Rebuttal Statement

I7/00587/OUTMAJ

ERECTION OF UP TO 46 DWELLINGS ON LAND OFF
SCHOOL LANE, FORTON

Prepared for Mr Whittingham

PROPOSED SITE PLAN

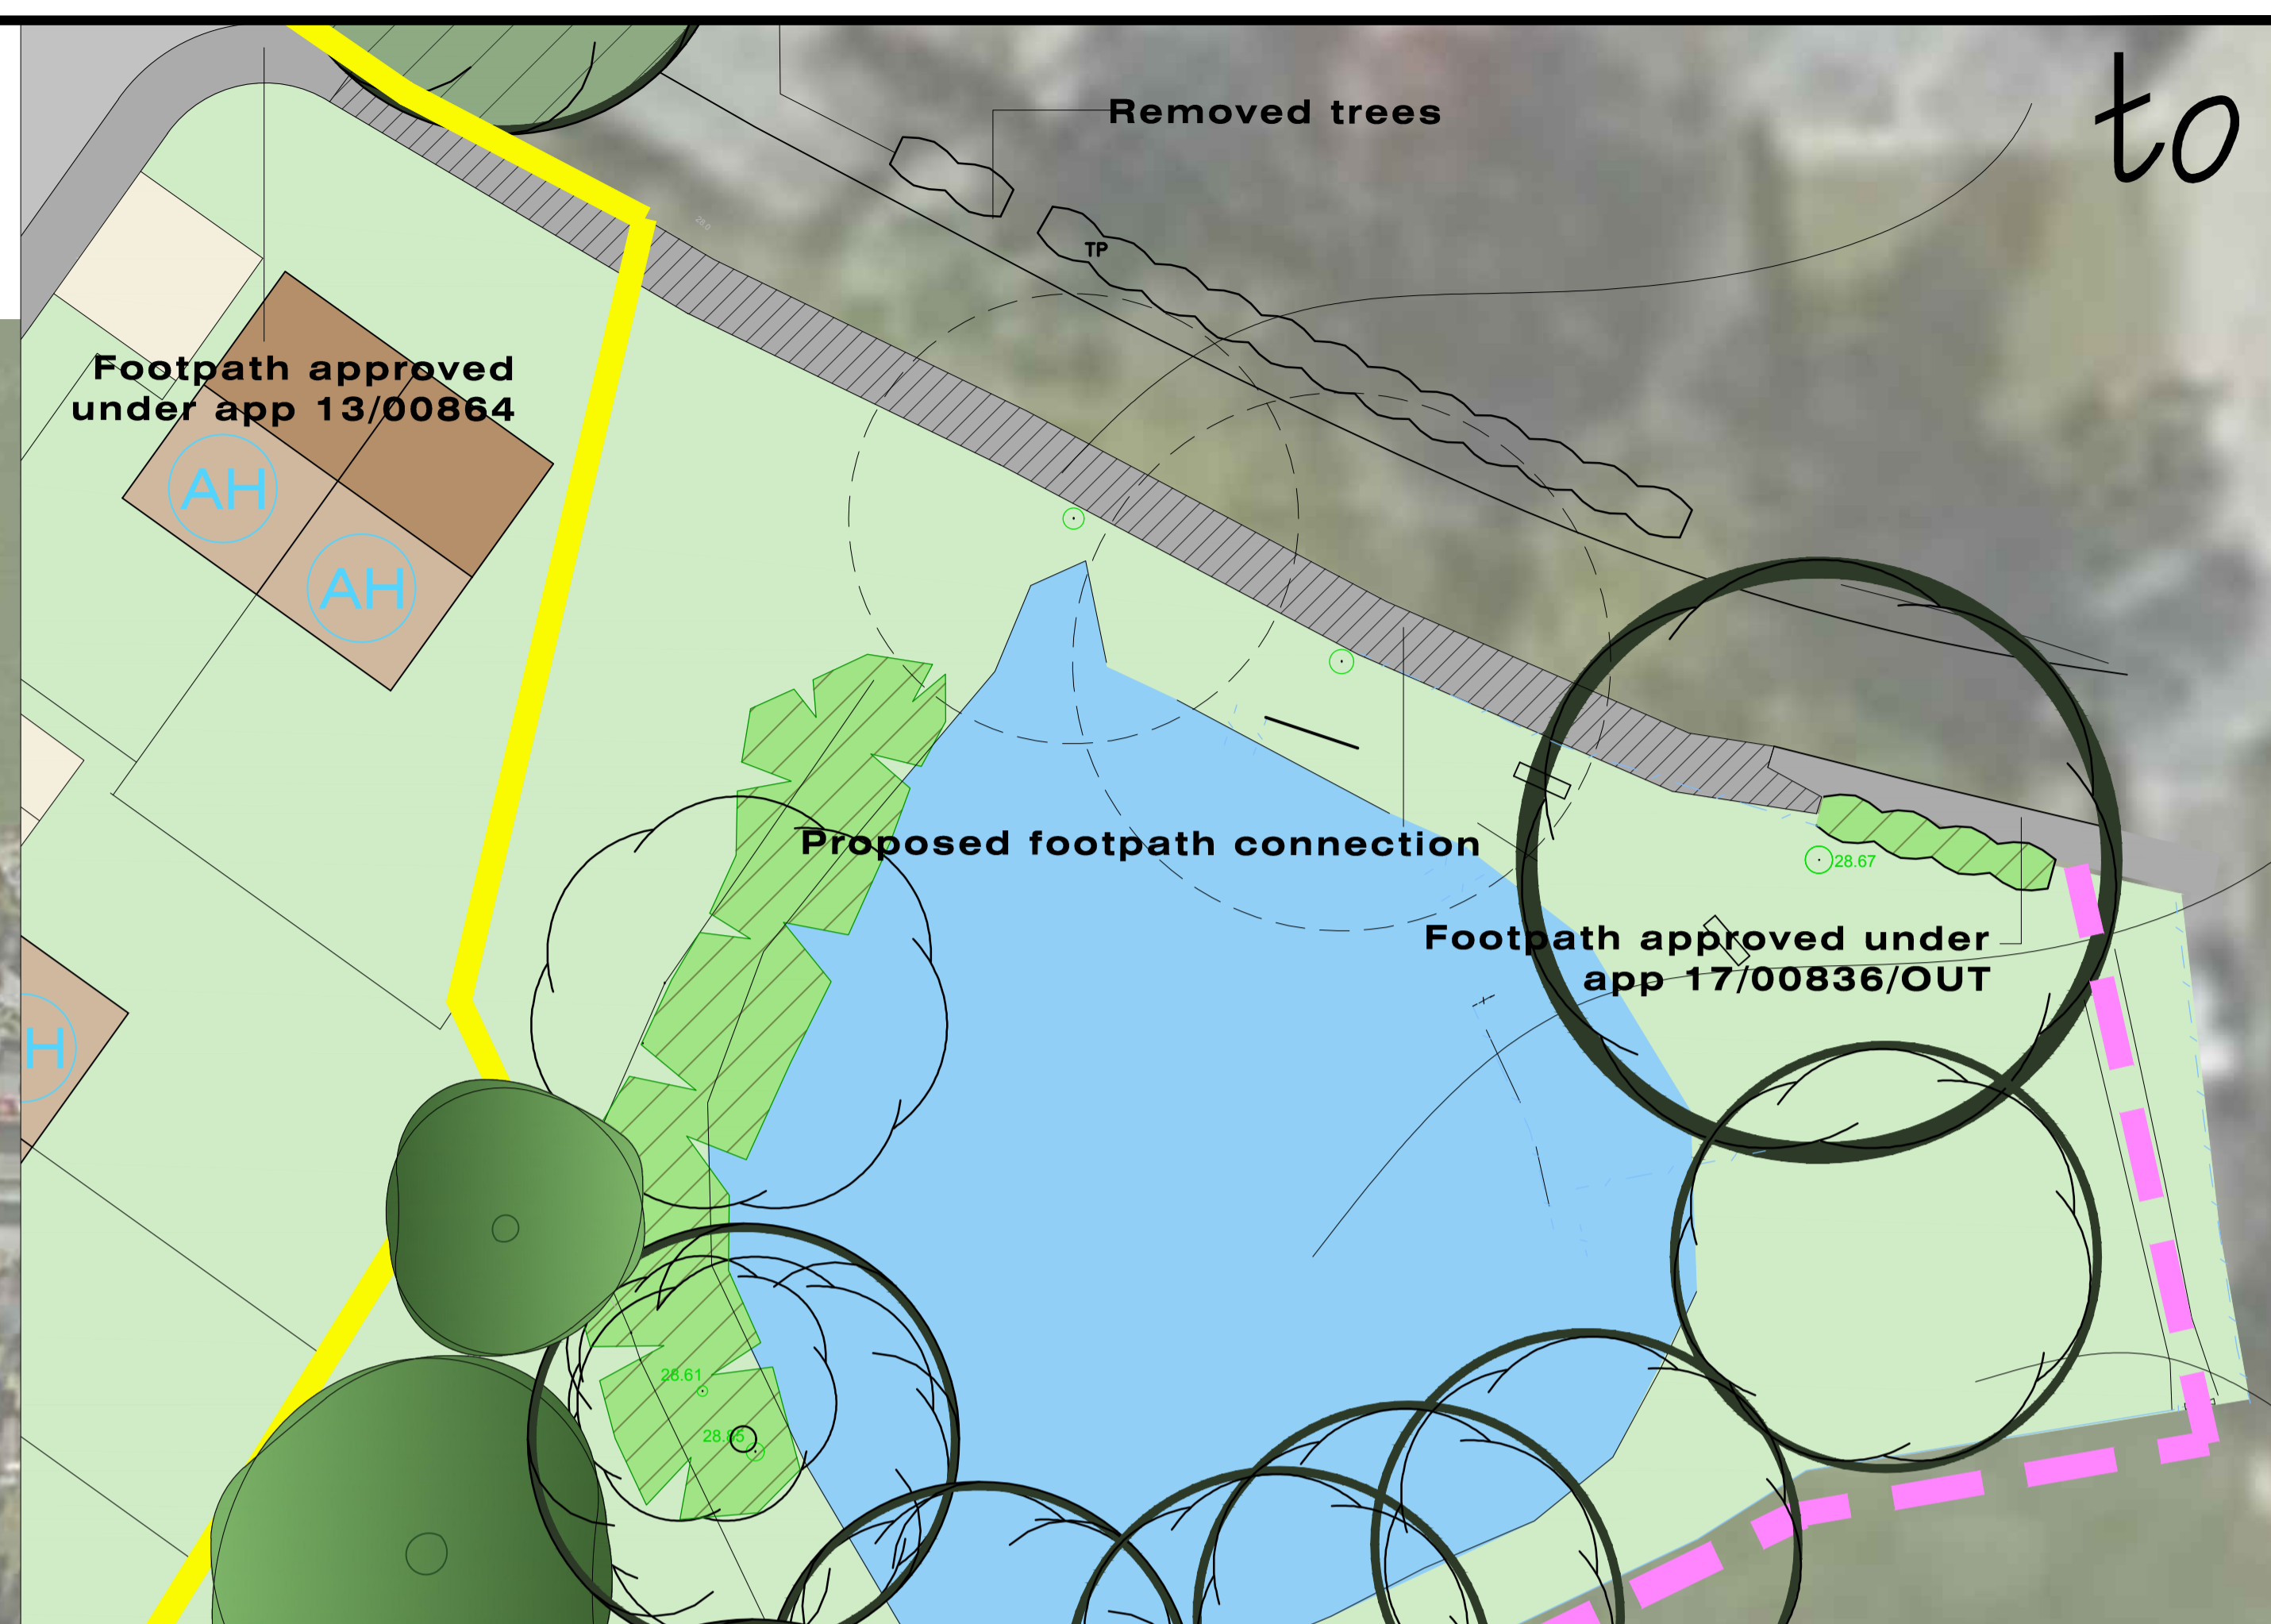
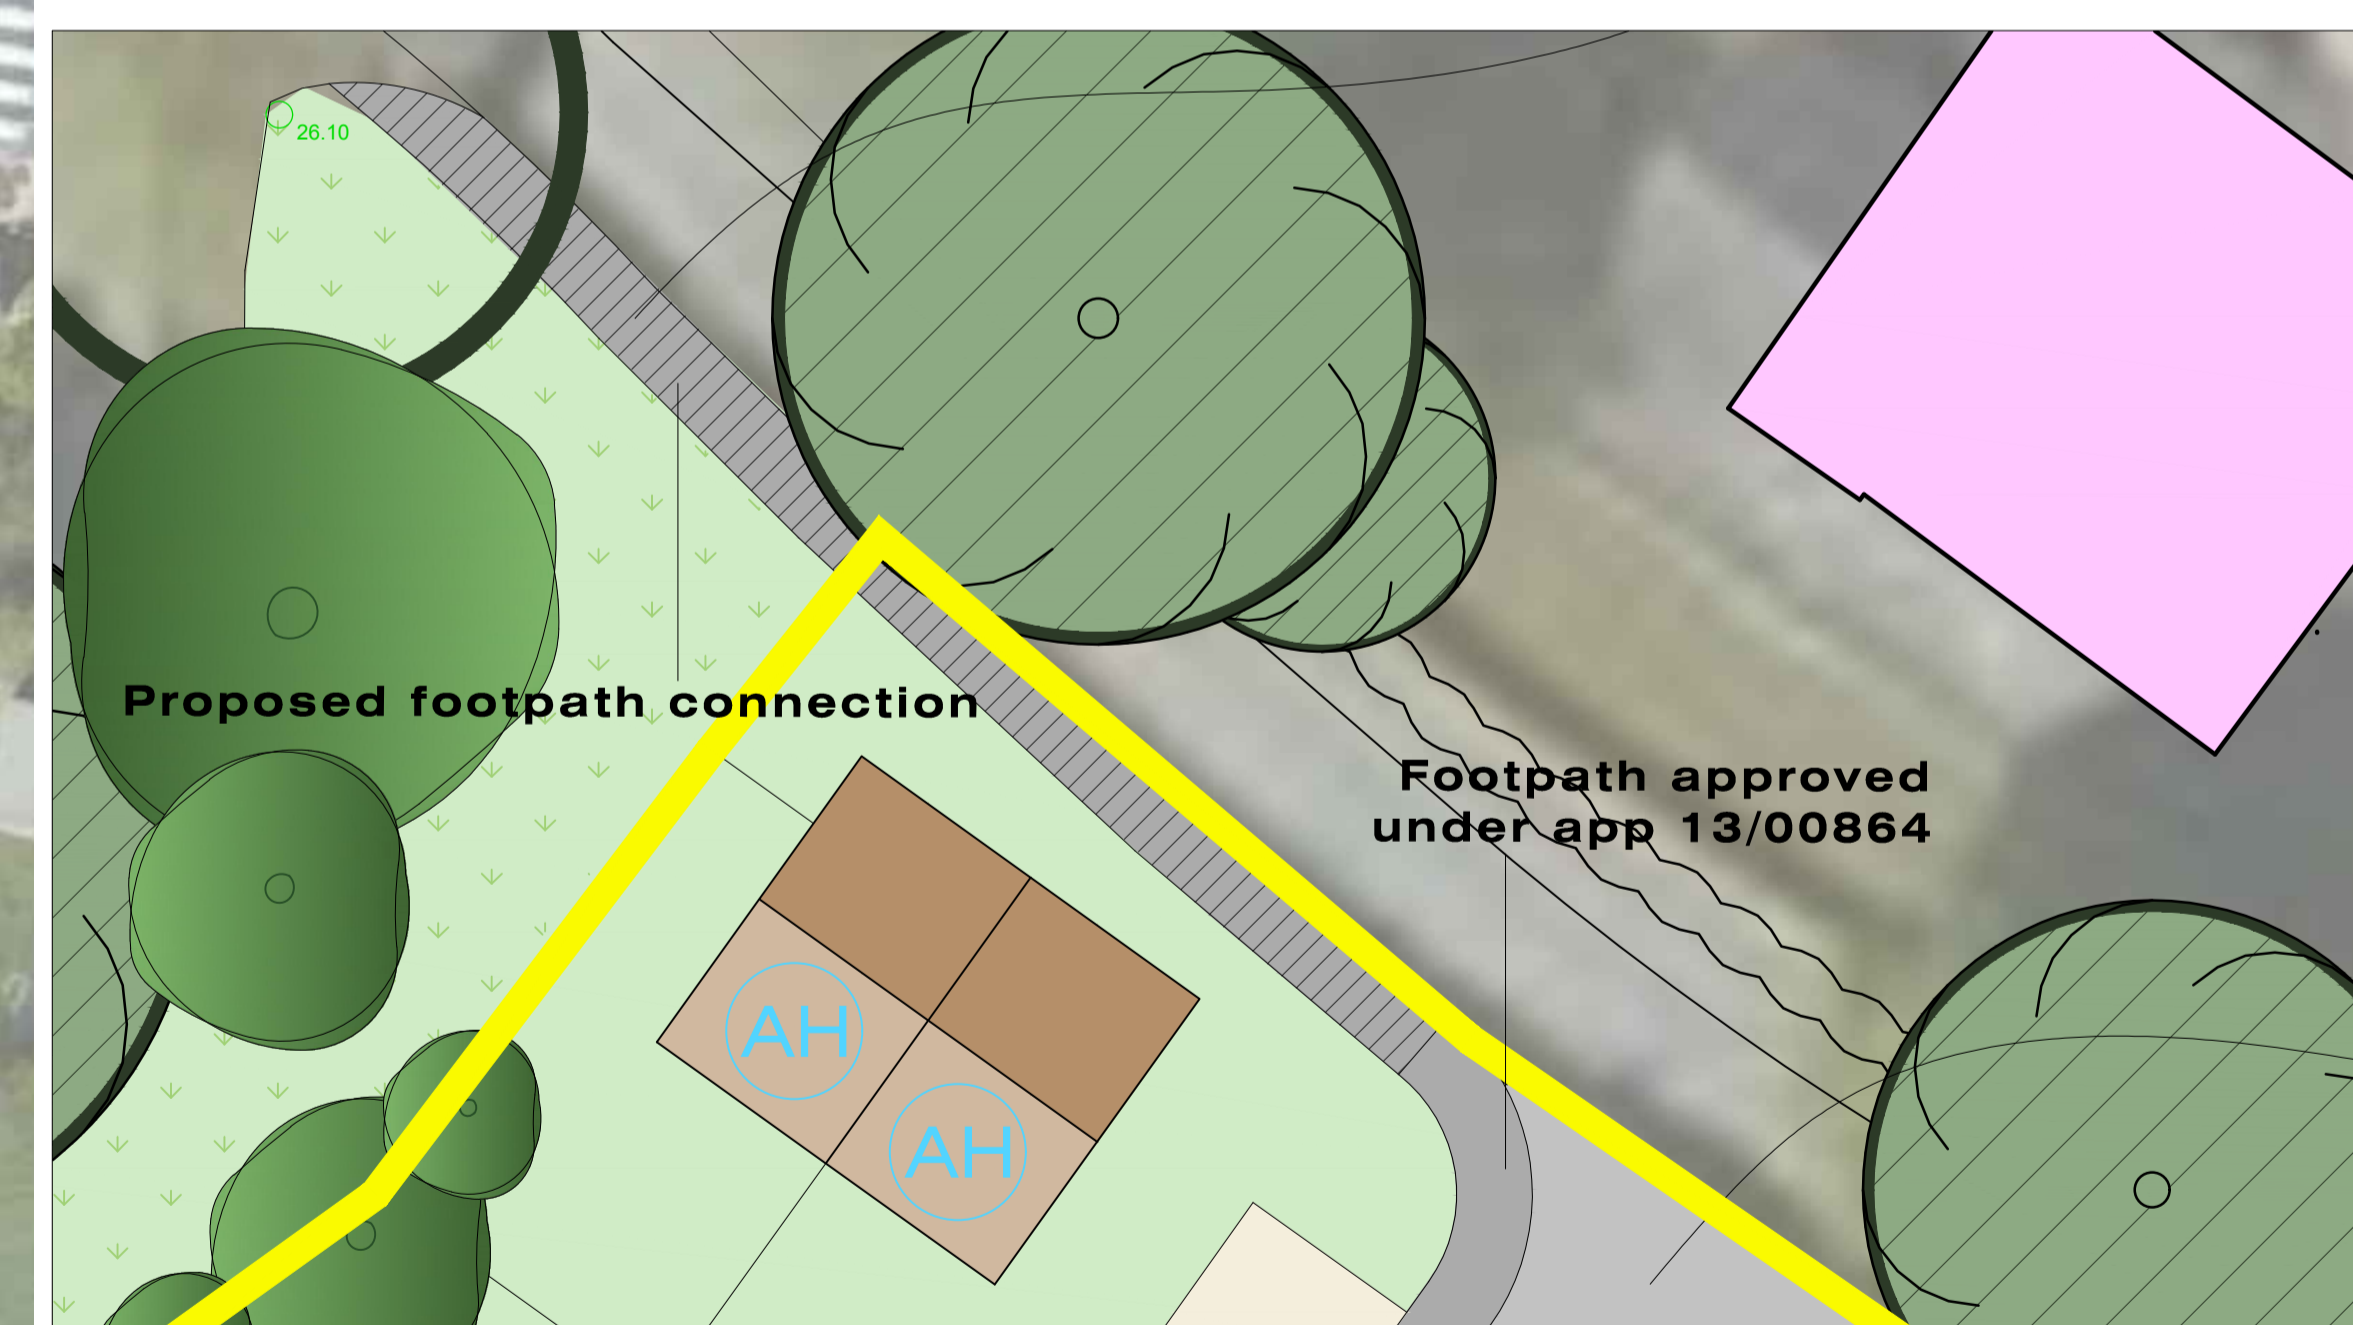
- 5.36 Paragraph 6.7 considers the submitted Site Layout Plan to lack a connection with Forton. Detailed proposals to illustrate the precise form, nature, design and scale of the development would be submitted as part of a reserved matters application and only at this stage would it be possible to assess whether the development has a sense of place. The indicative layout proposes:

- predominantly 2 storey dwellings in a mix of detached, semi-detached and terraced – reflecting existing dwelling types in Forton;
- an area of public open space on the north eastern part of the site – related to the setting of the cricket ground;

- retention of existing trees along the southern boundary of the site and within the proposed public open space – retaining landscape elements common to the Forton-Garstang-Catterall landscape character area;

- retention of existing hedges and trees on the north western, western and southern boundaries of the site – retaining landscape elements common to the Forton-Garstang-Catterall landscape character area; and

- proposed trees on the site boundaries and within the site – to implement a strategy for the Coastal Plain landscape character type to introduce new tree planting using native species within and on the fringes of the development to improve views and approaches to the built edge of Forton .
